**Re: Bedrock at The Trails Units 2 and 3 at 9300 Woodmont Ave. NW
Erosion and Sediment Control Plan
CPESC Stamp Date 11/21/24 & PE Stamp Dates 7/18/24 & 7/31/24 (C09E011B)**

Based on the information in your submittal received on 11/26/24 consisting of Sheets ESC 1-3, the DMP, and 39R and 40R of the Phase 1 work Order Plans, the following comments must be addressed before approval.

BEDROCK
POND A6-1 & POND A6-2

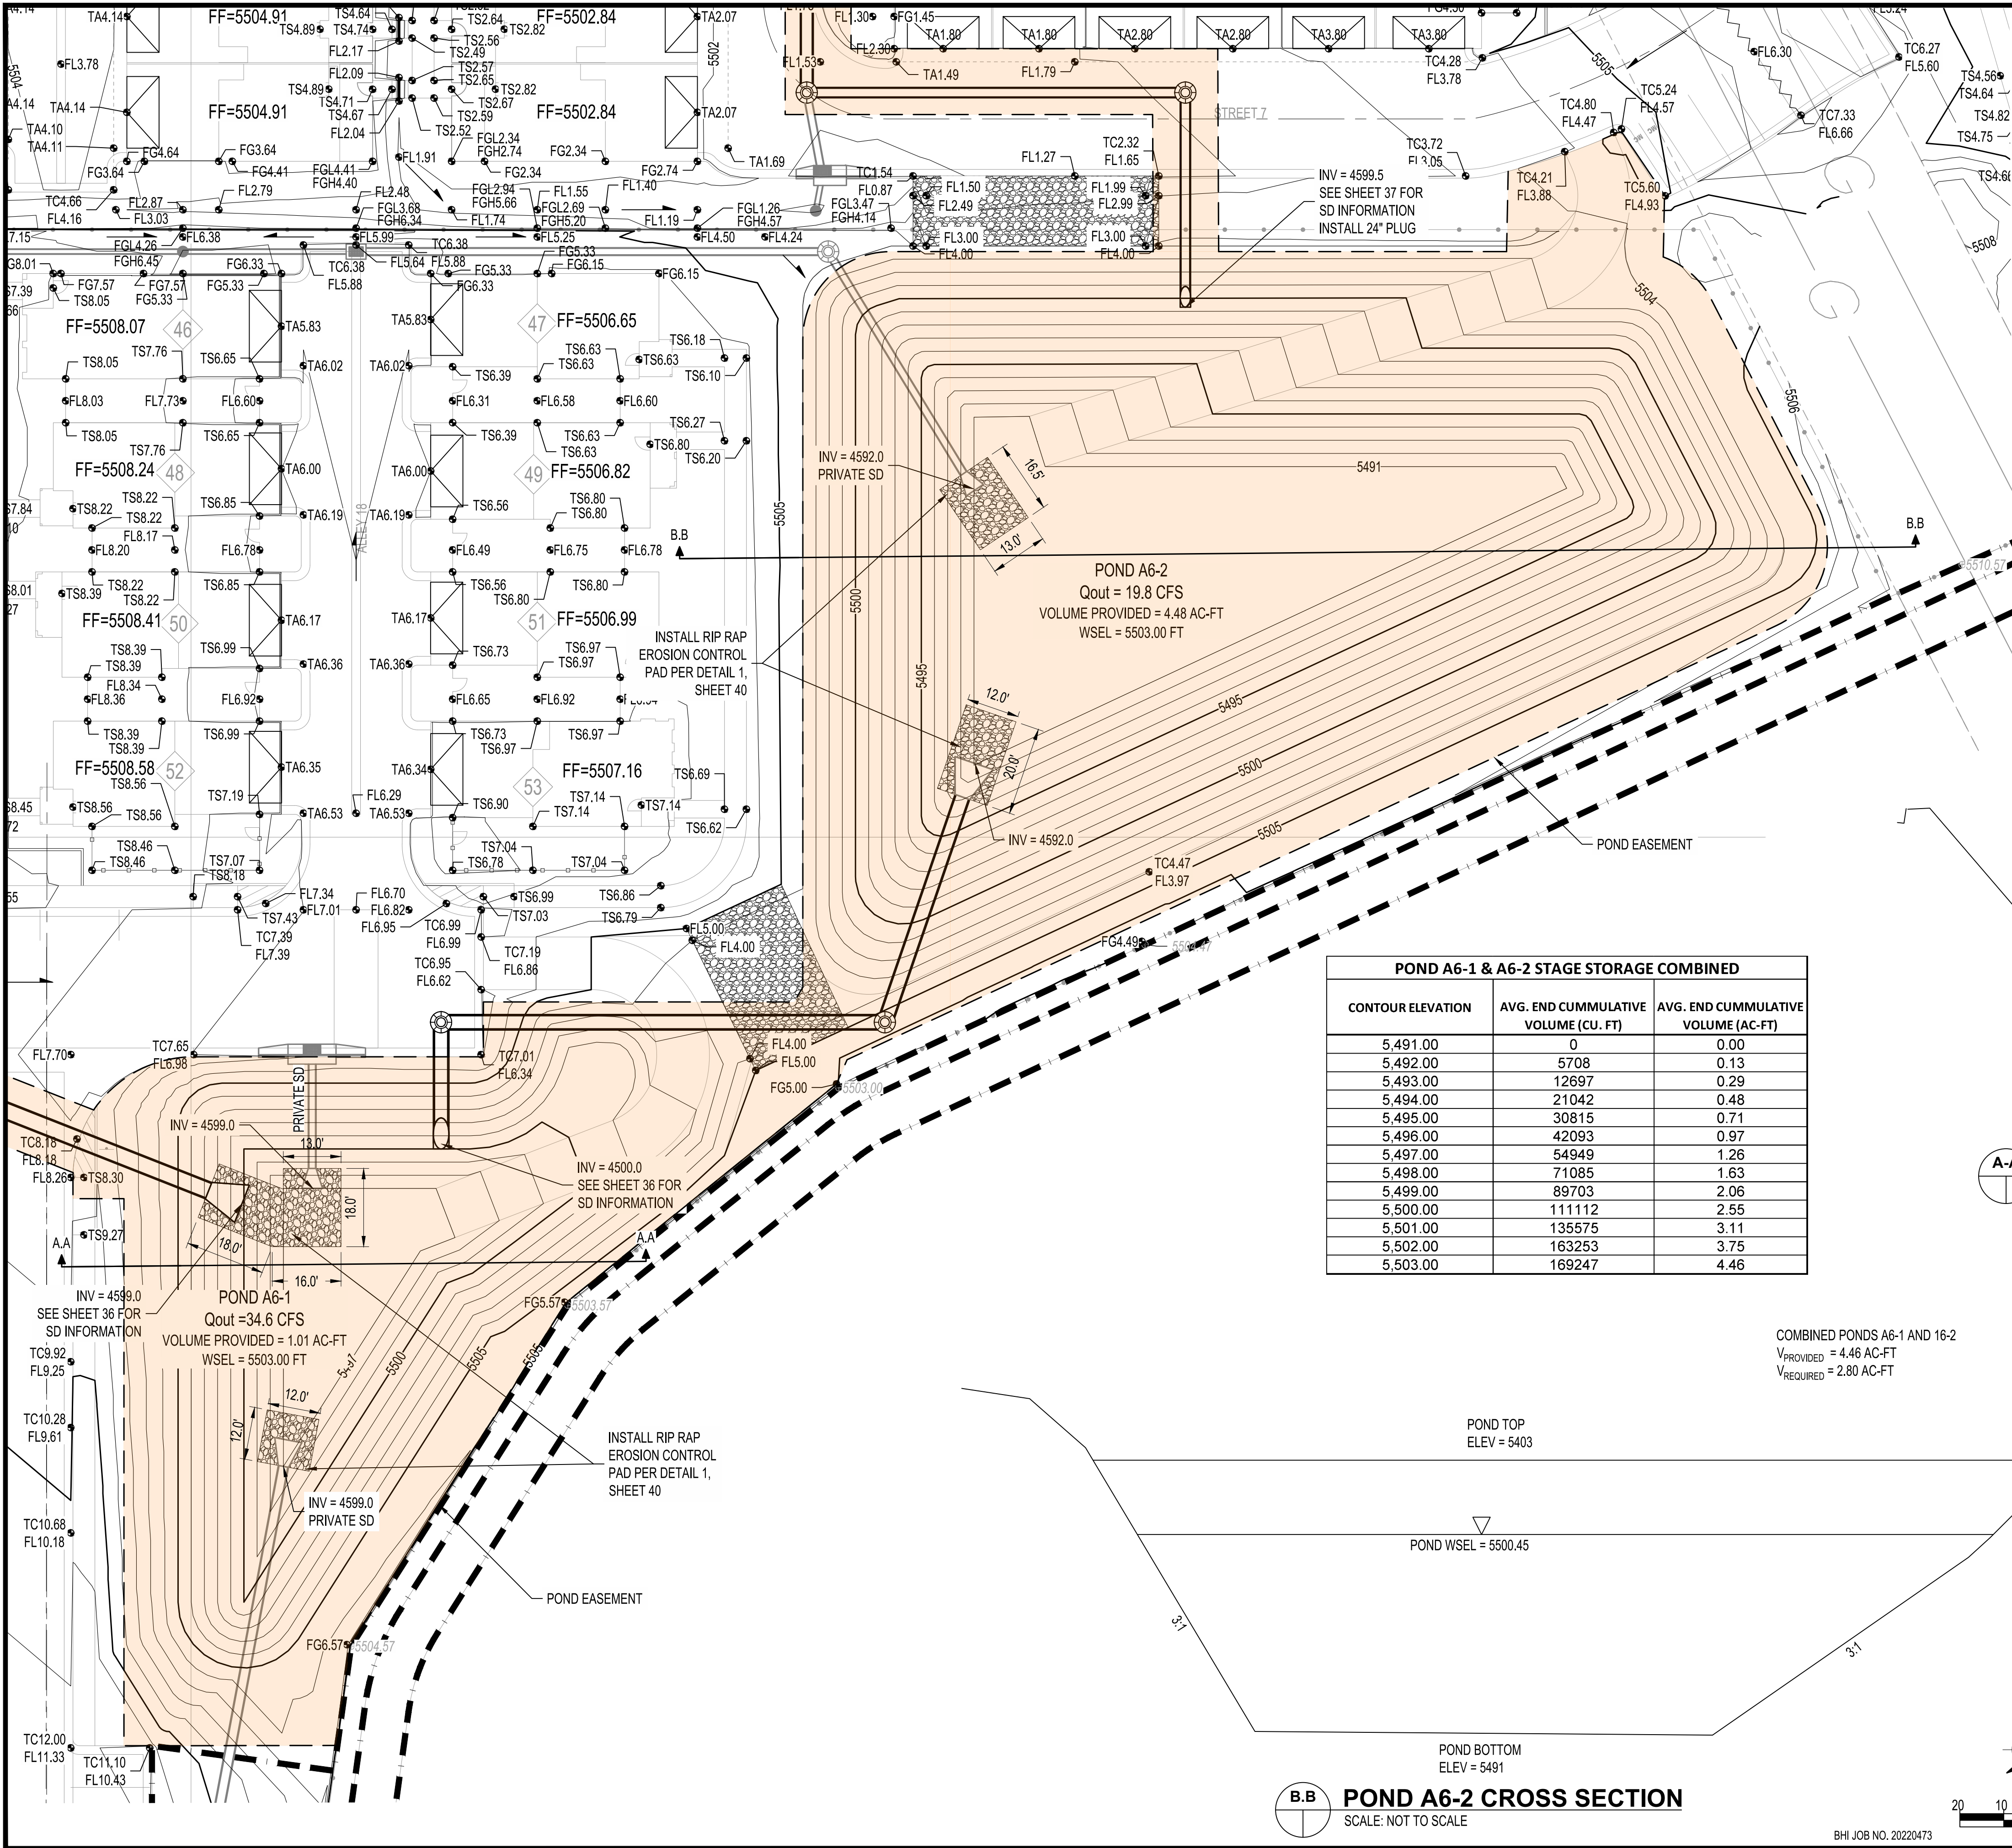
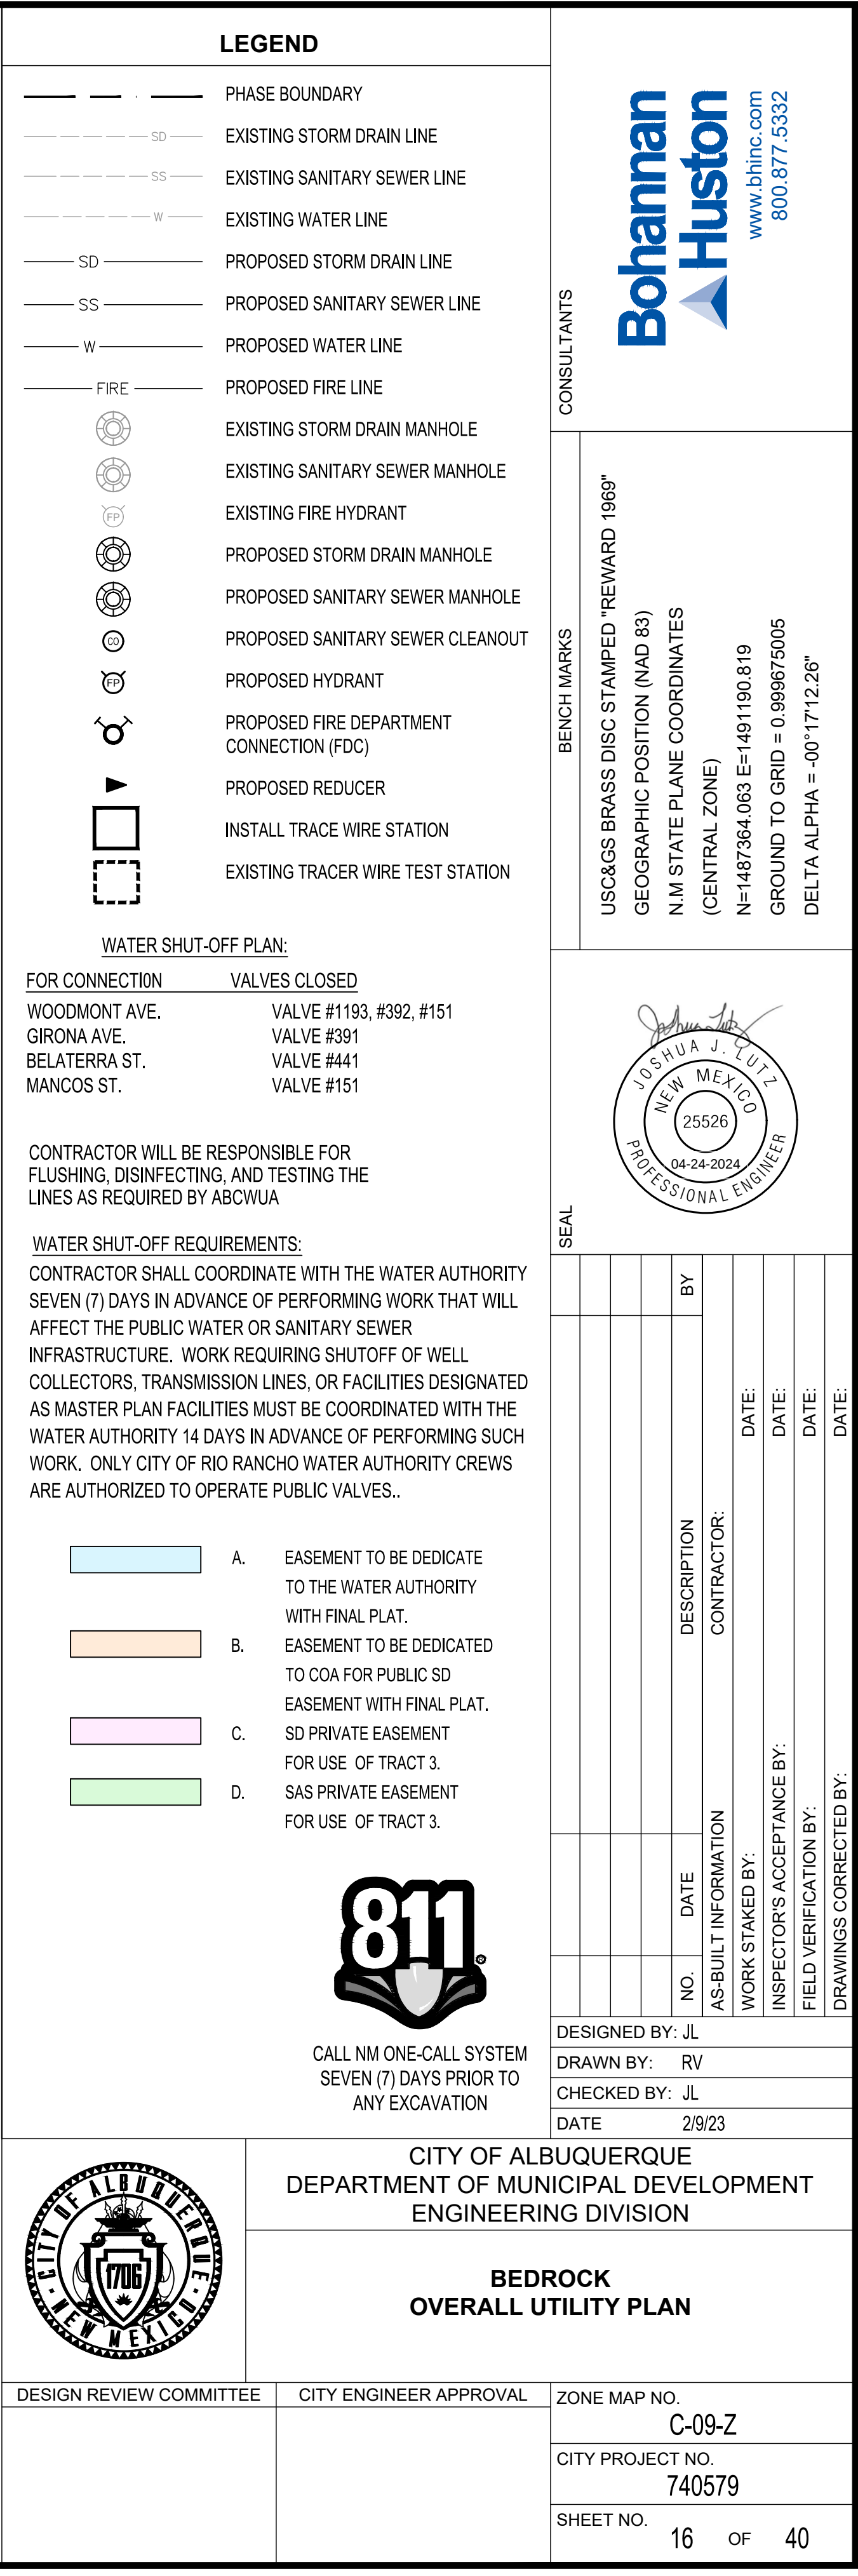
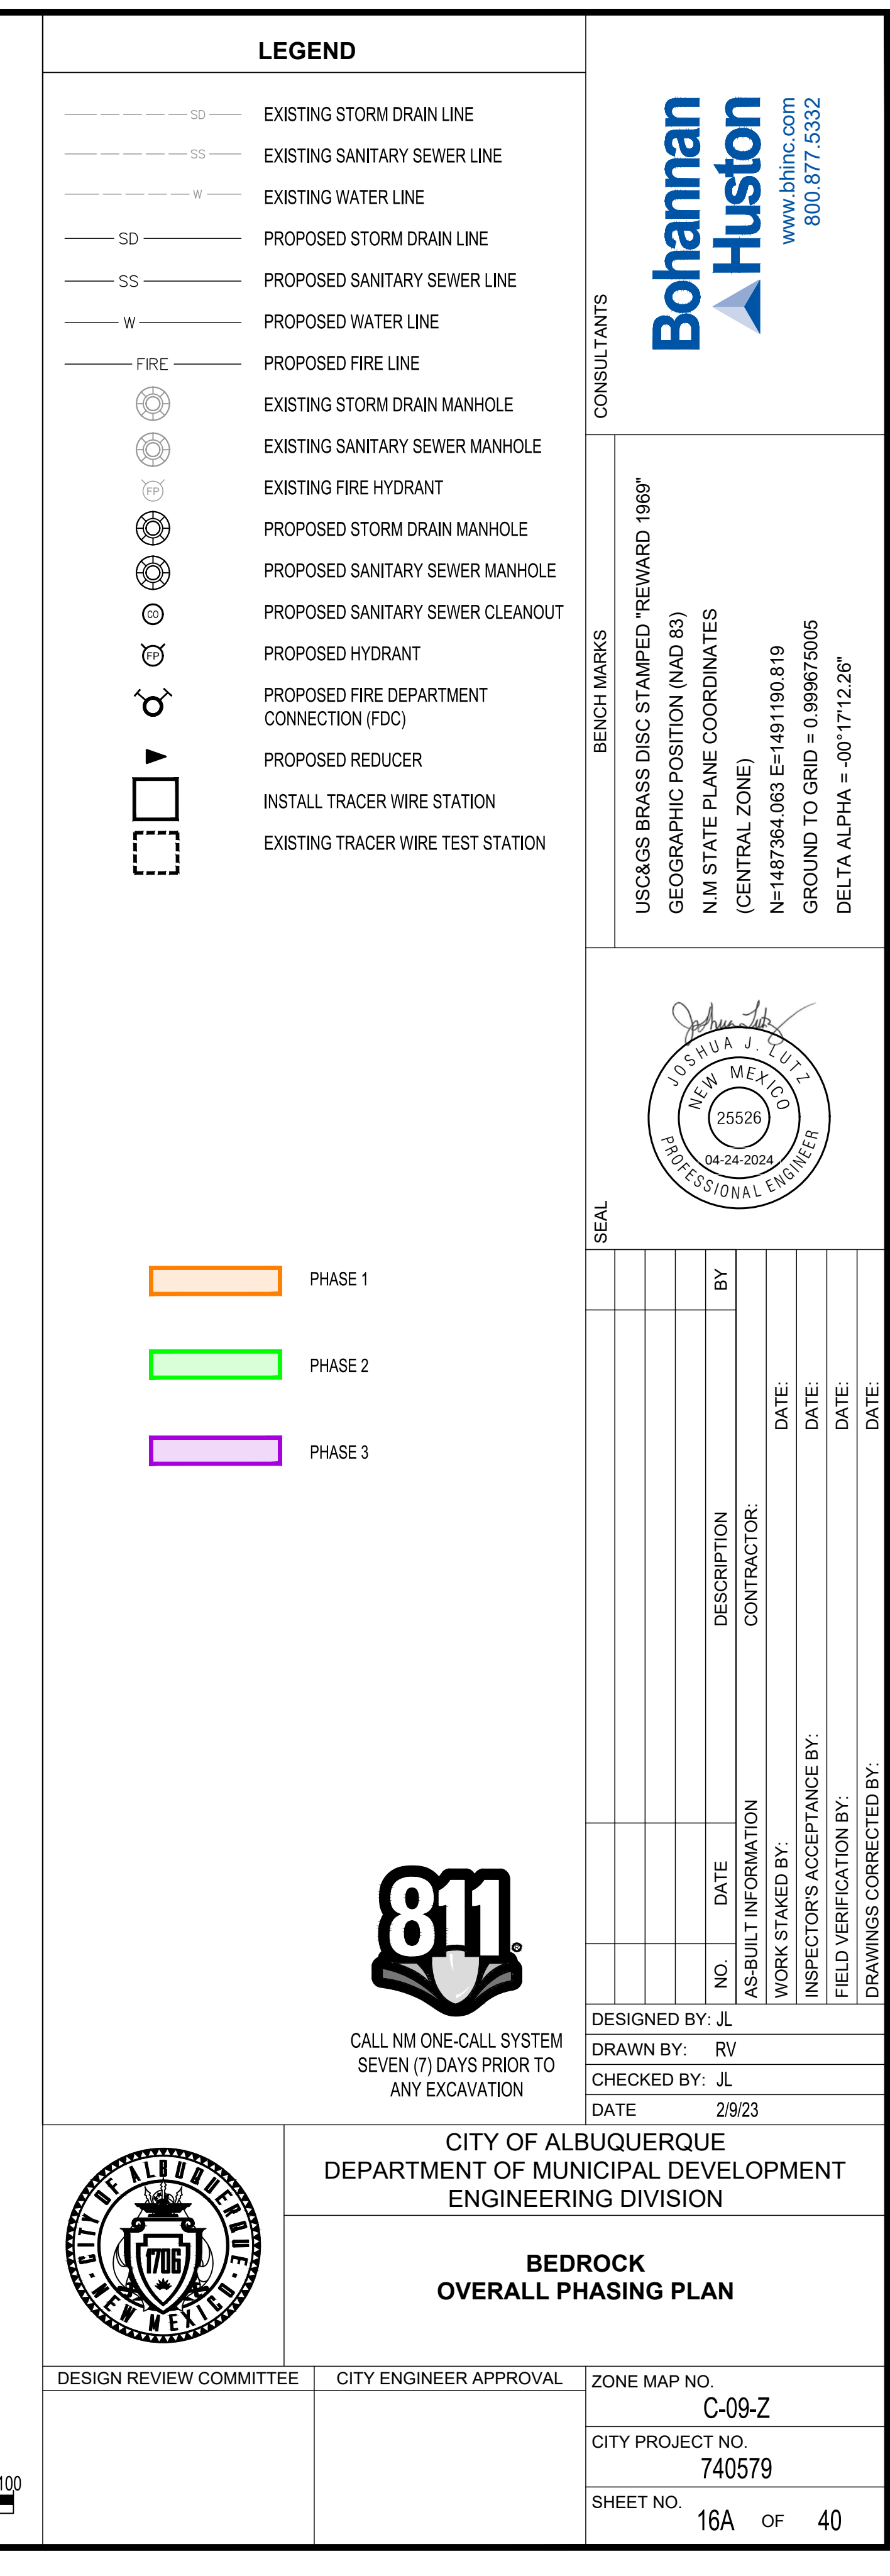
1. The construction sequencing on sheet ESC-2 says, in essence, that the outfall pipes from ponds D1 and A6-2 will be plugged until all of the buildings and infrastructure construction and stabilization are complete. However, the engineering sheets don't indicate that that condition is safe, nor is there any indication that the condition has even been considered by the professional engineer (PE). So, provide a hydrologic summary of how those two ponds will function with plugged outlet pipes at full buildout. The summary should be stamped by a PE and included in the Work Order and ESC Plans. The summary should include a description of the conditions, the 2-yr and 100-yr 24-hour volumes, peak flow rates, and peak stages in all ponds.

2. The plugs should be specified on the Work Order Plans as RCP Caps with gaskets or approved equal.
3. Specify on the Work Order Plans the timing of the cap removal, sediment removal, fine grading, and final stabilization per STD Spec 1013 for all onsite ponds acting as temporary sediment basins.
